Technical Response

Project: Lidl New Hey Road

Project reference: 16-3046

This technical note provides a detailed response to the comments provided by Lead Local Flood Authority dated 5th January 2025.

| Title | | DRAINAGE ARRANGEMENT SHEET 1 OF 2 | |

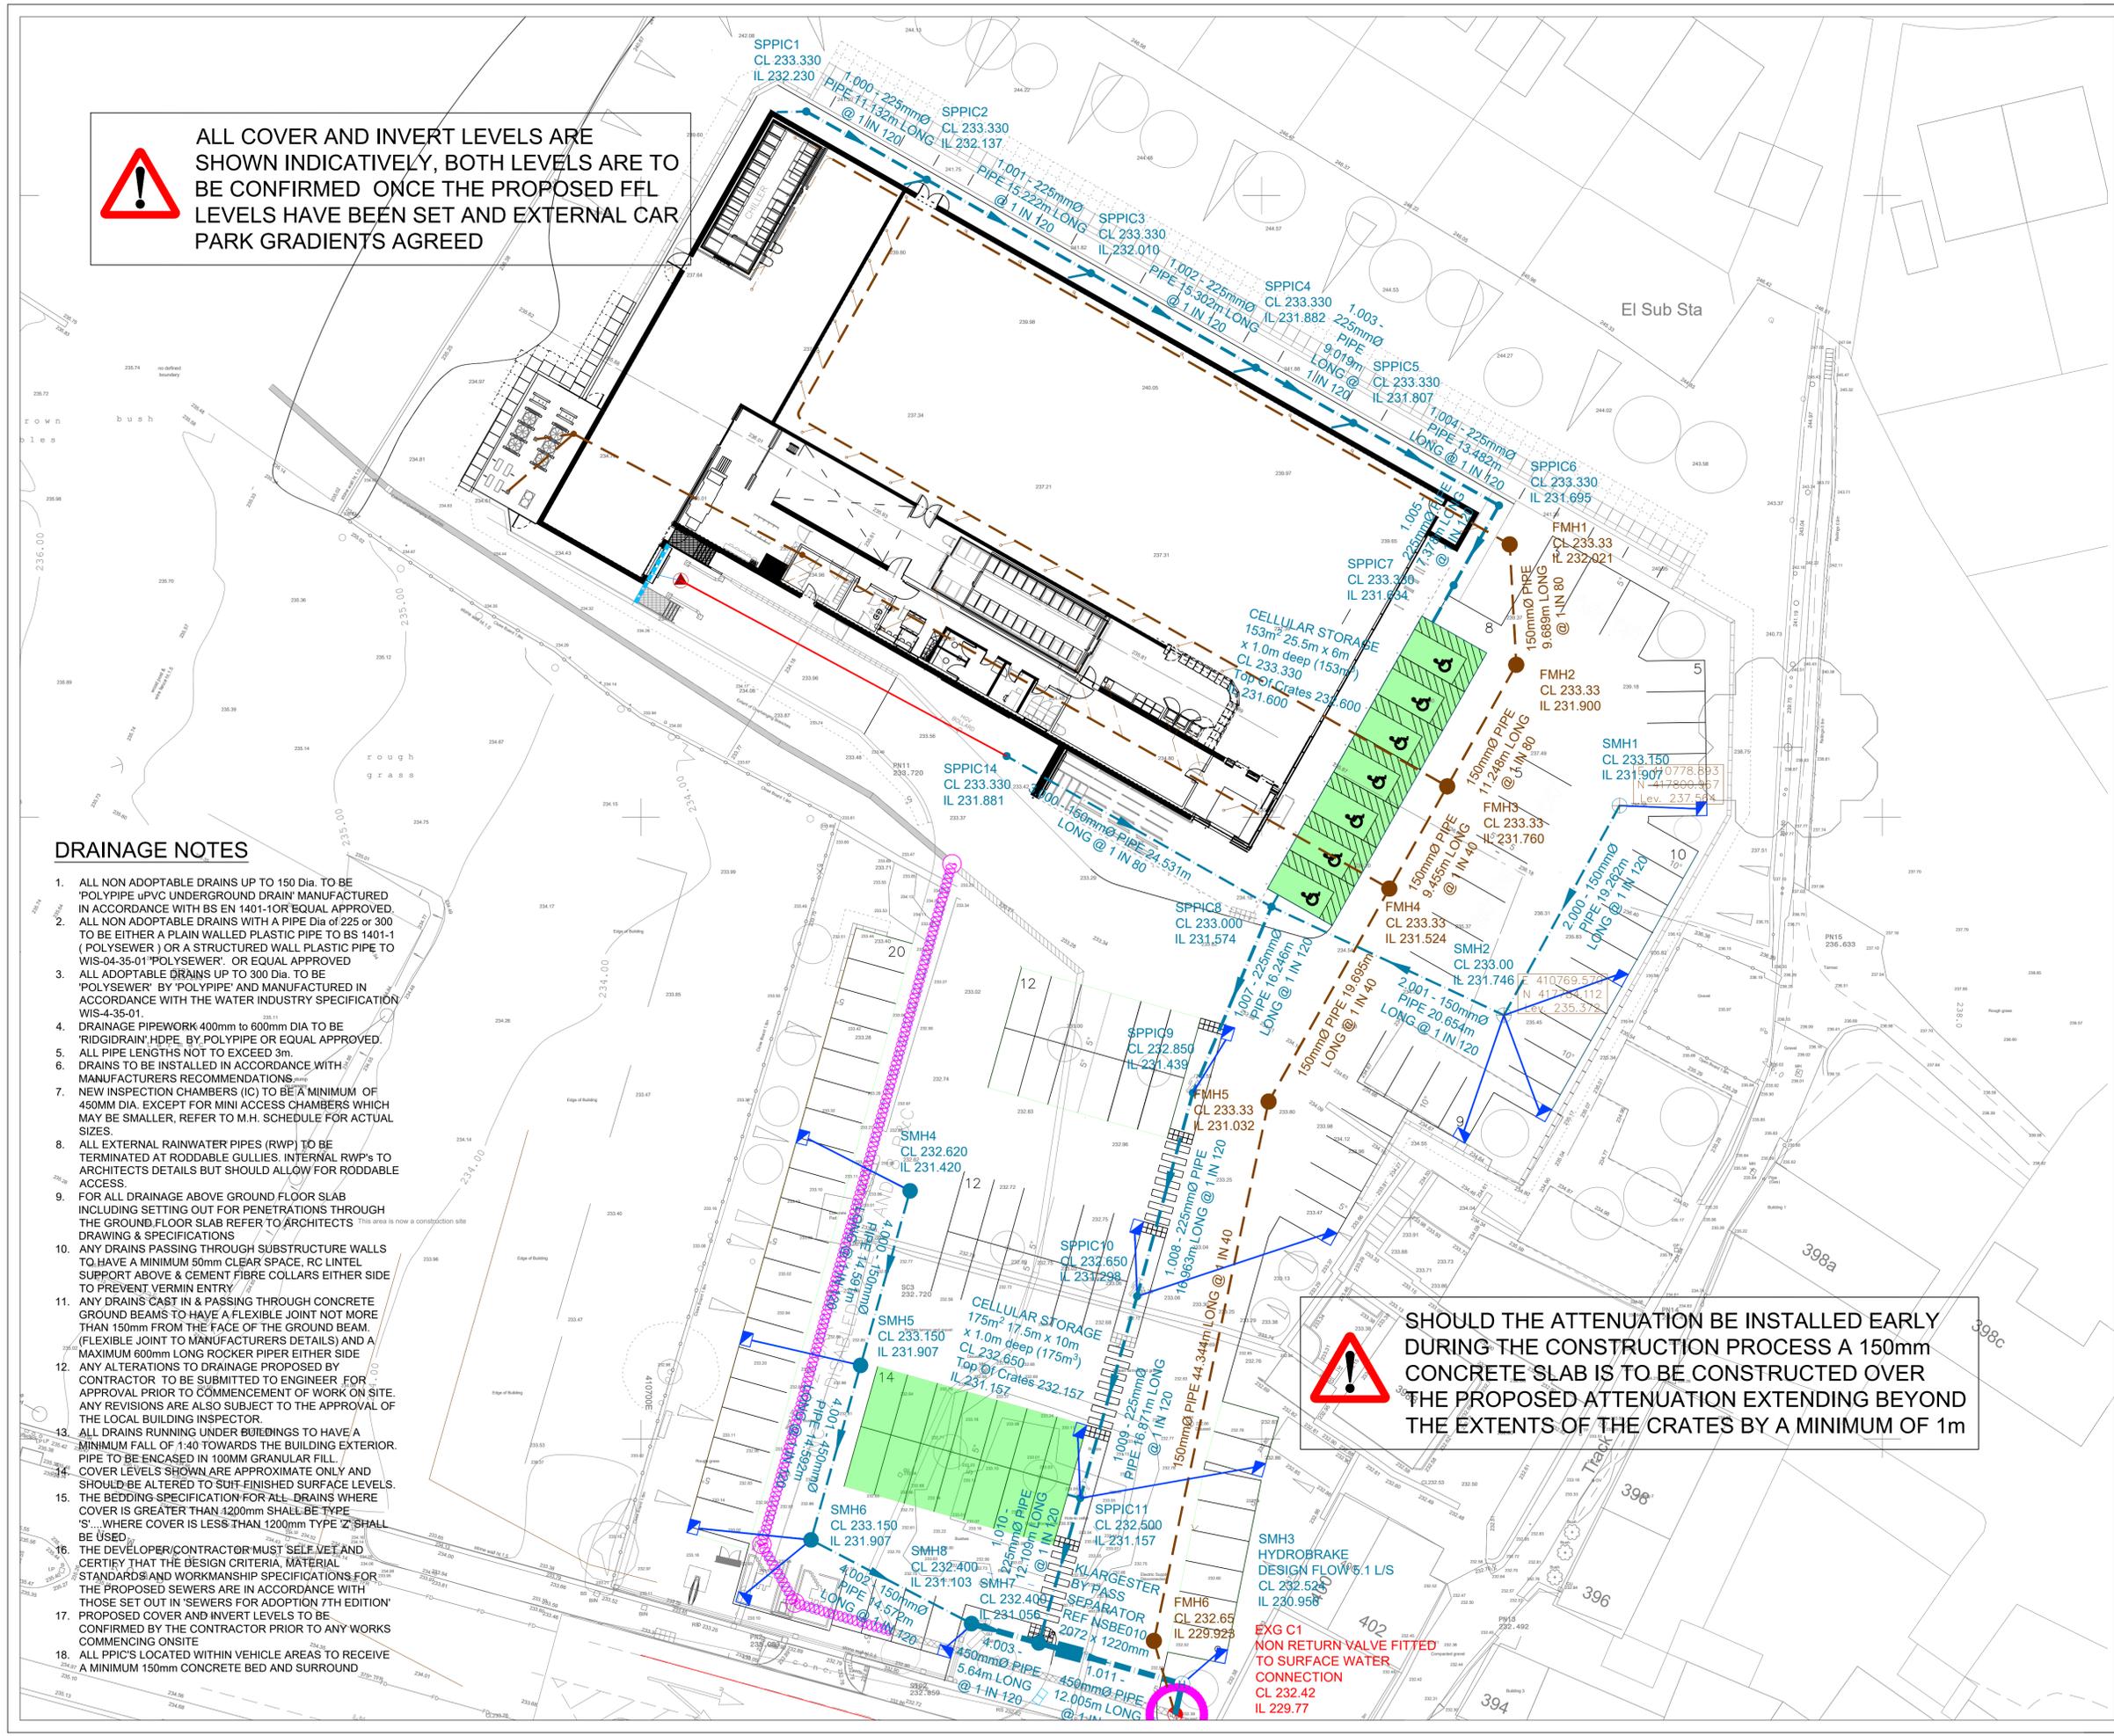
1. *An assessment of the max weight of vehicles to be visiting the site (HGV's, e.g. delivery trucks) in relation to minimum depths required from polystorm R is still required. One of the tanks has less than 500mm in cover and would appear to be non-compliant.*

Neither of the attenuation tanks will be subject to HGV loading vehicular swept paths have been included to resolve the above concern. Despite this, we have included a requirement for a protection slab to ensure this is not an issue during construction.

TYPICAL ATTENUATION TANK PLAN

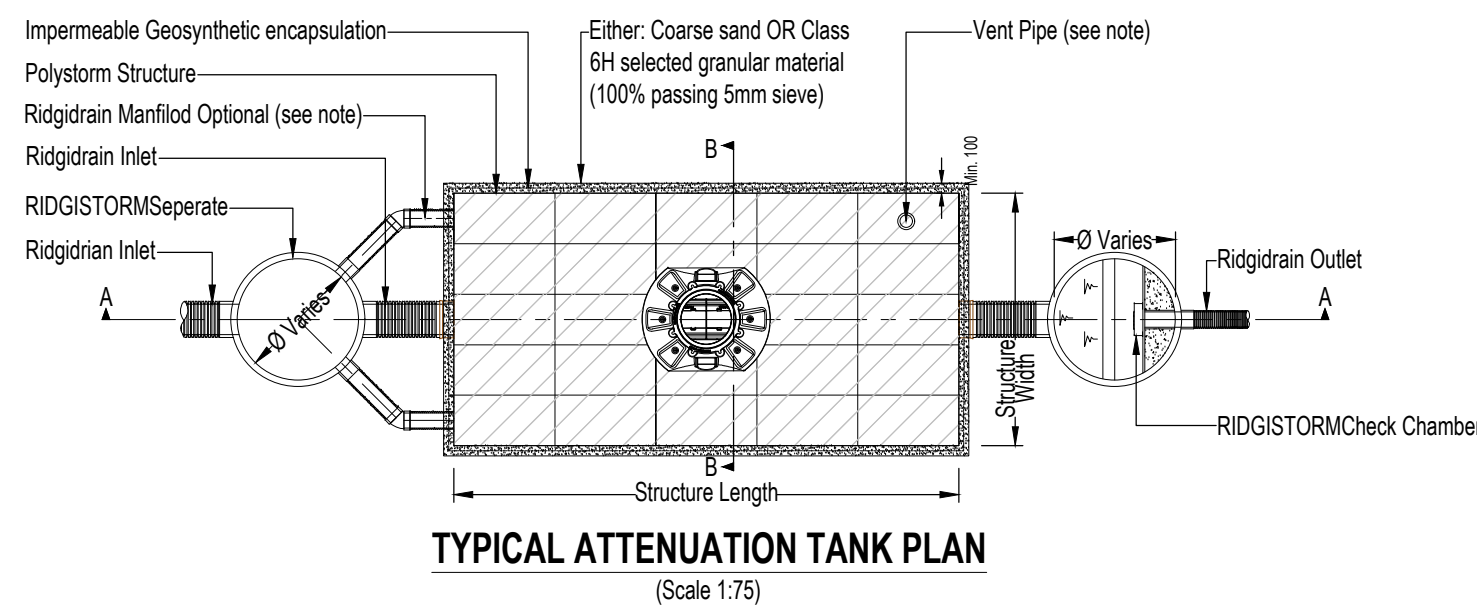
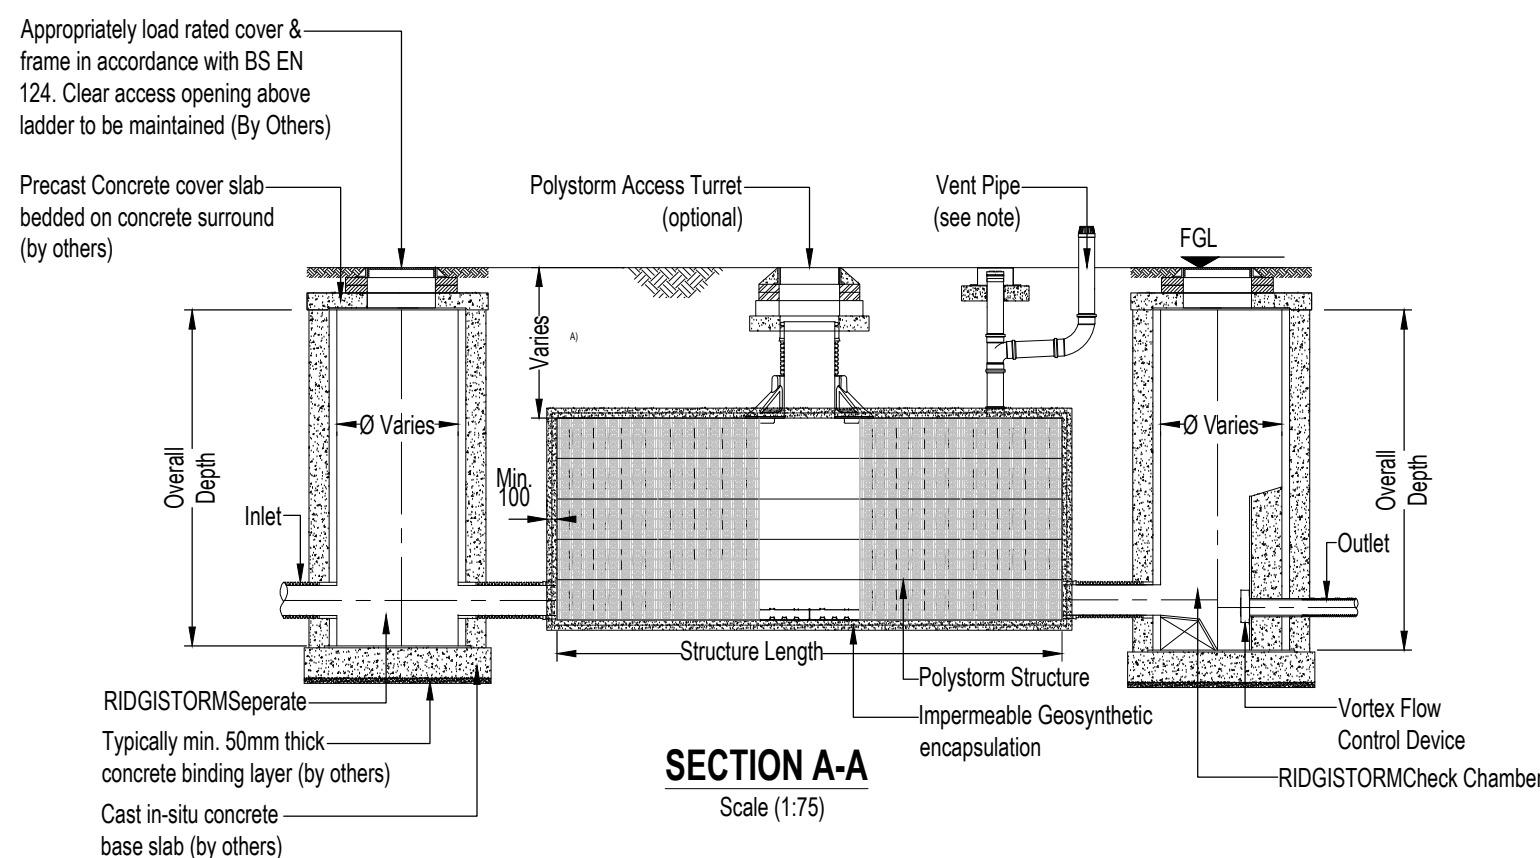
2. *One of the tanks has only one catchpit to work from. Central or intermediate access (shown on typical drainage details) appear to be omitted from the final design. This compromises the language of the maintenance plan.*

All cellular attenuation features can be installed at any depth to invert within reason, with the average depth to invert through the 2 storage facilities being approximately 1.5m with the minimum depth to the top of the cellular system being 400mm, which is sufficient to accommodate the proposed car park construction depth with no HGV movements anticipated, additional information has been added to the drawing for clarity.

A protection slab can be installed if required during construction.
